REPORT UPDATE

Application No: EG/57/14/A

REF NO: EG/57/14/A

PROPOSAL: 1 No internally illuminated fascia sign, 1 No externally illuminated fascia sign, 1 No externally illuminated projecting sign, 1 No non illuminated wall mounted dibond panel on front elevation.

PROPOSED FRONT ELEVATION

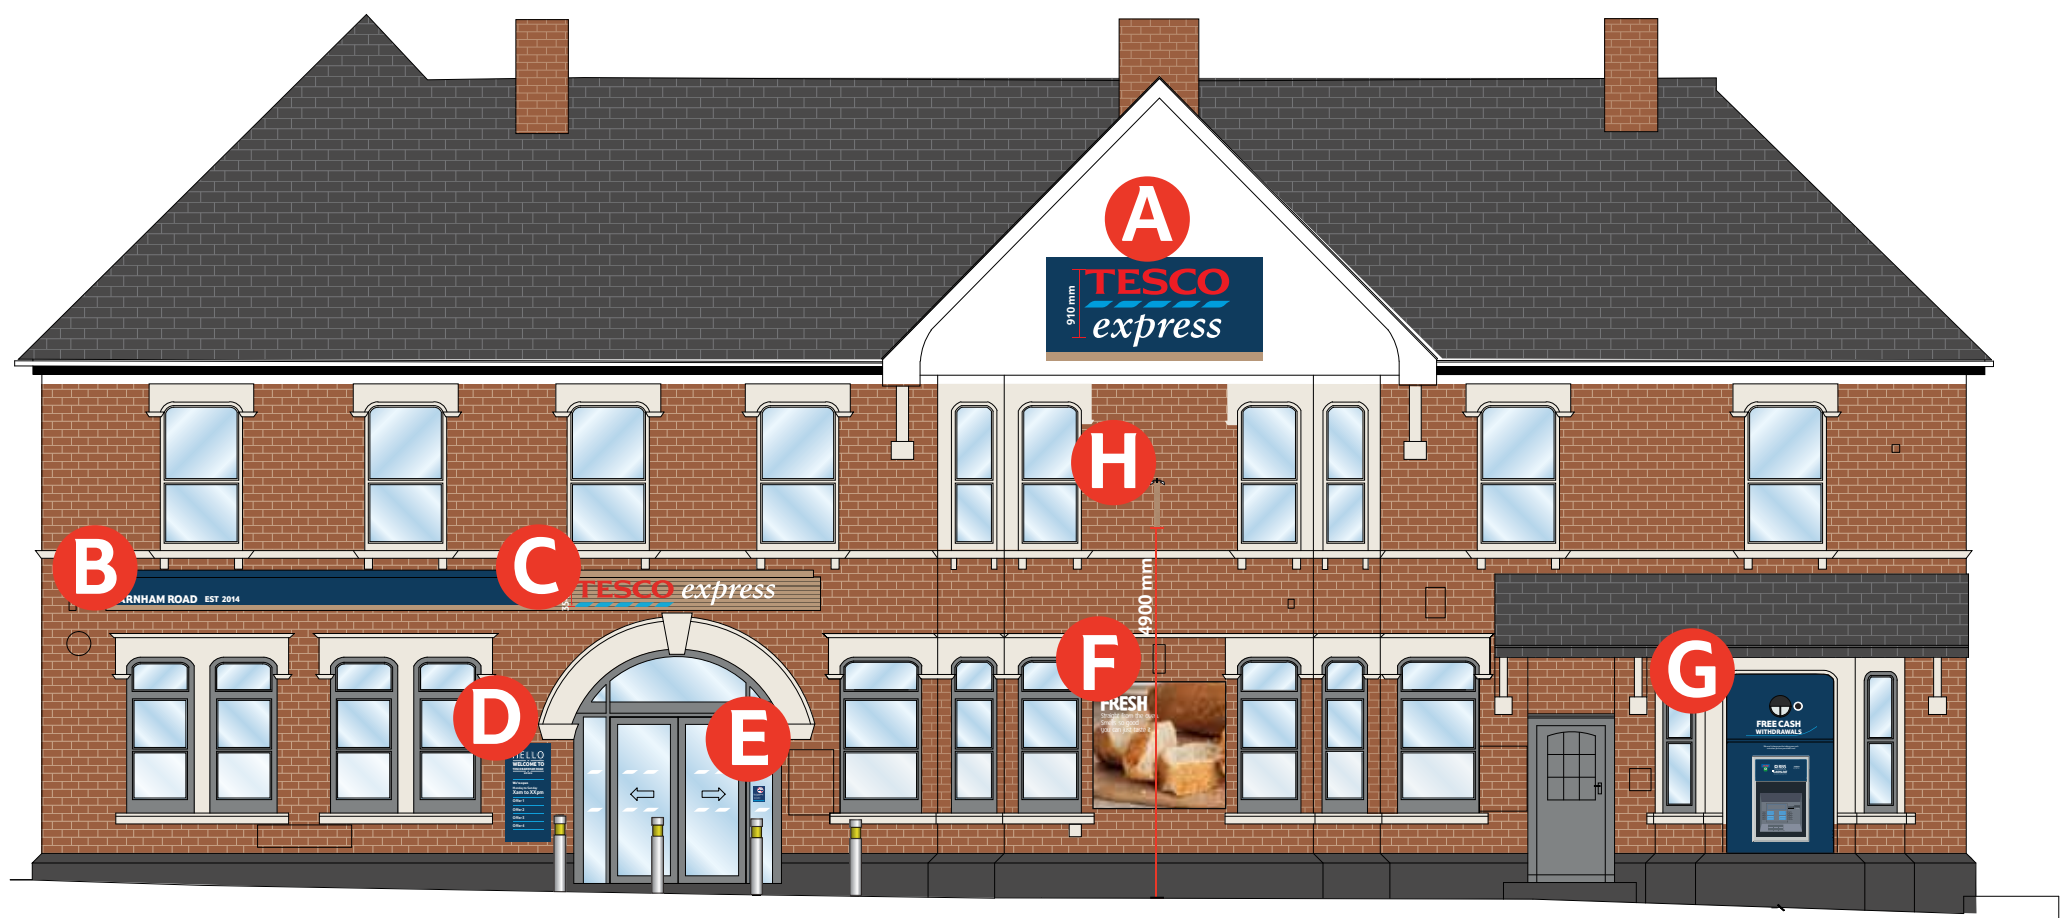
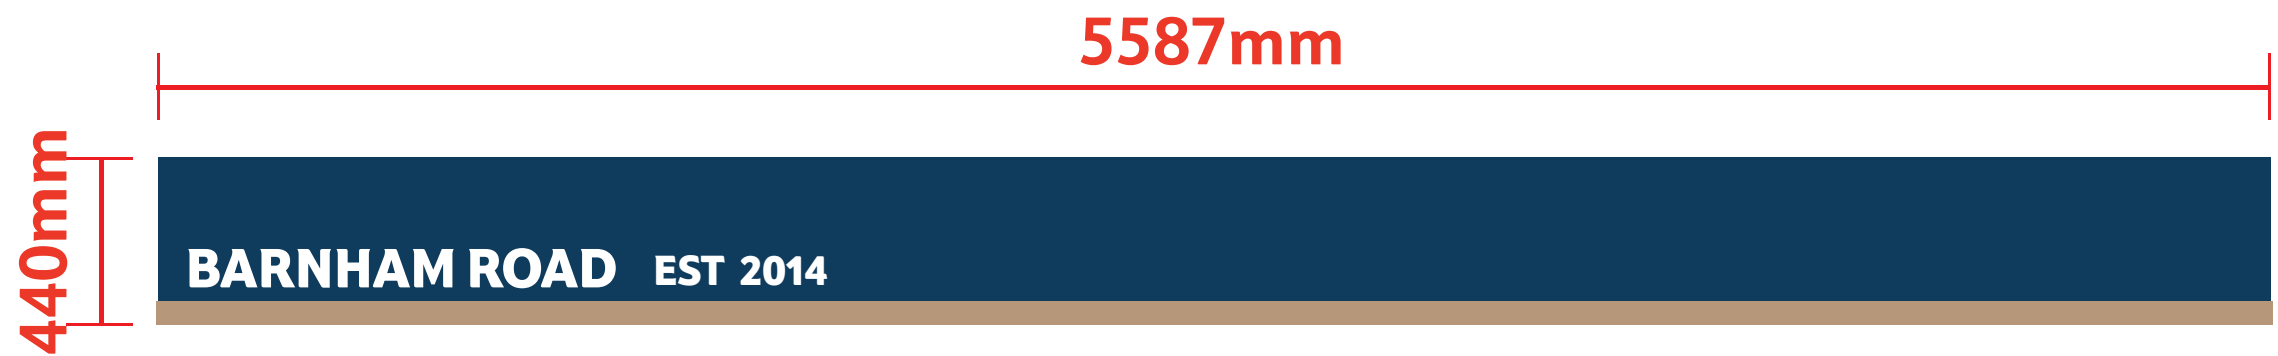
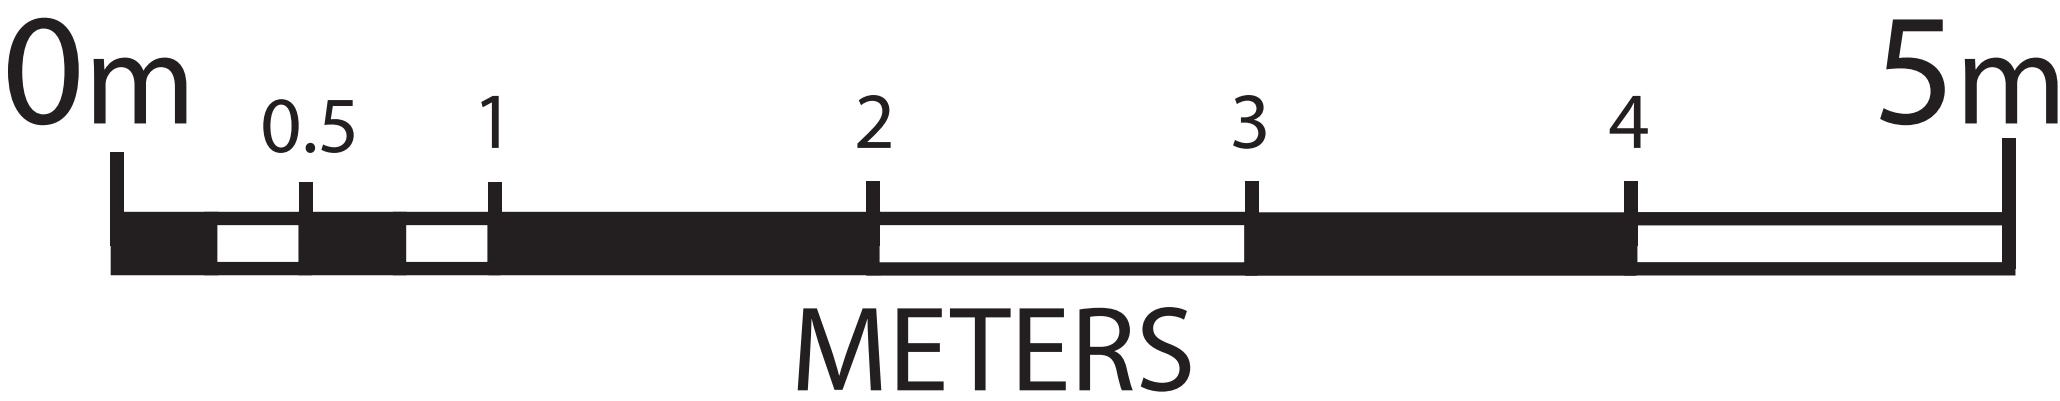
There has been a slight change to the submitted plans in that the lighting to Sign B has now been removed. Members should note that Sign B is the narrow rectangular blue fascia panel to the left of the entrance door as viewed from the front. This is reflected by the amended plans condition shown on the attached sheet.

Advert B: I question the need for such a sign - could the text be included in Advert C (maybe in the bottom right corner. This sign should be deleted.

Advert F: This is a particularly large sign that it is considered detracts from the character and appearance of the property. It is considered that such a sign is not required; there is enough information for people to understand what the building will be used as. Further, most people are aware of the services offered by such a store. This sign should be deleted.

"The removal of the sign at the ground floor is supported. However, whilst it is considered that new sign B is acceptable, the concept of lighting it is not required."

SECOND CONSULTATION FOLLOWING REMOVAL OF 'SIGN F' BY APPLICANT & REMOVAL OF LETTERING FROM 'SIGN B.'

Noted. A request has been made to the applicant for the removal of the trough lighting on Sign B.
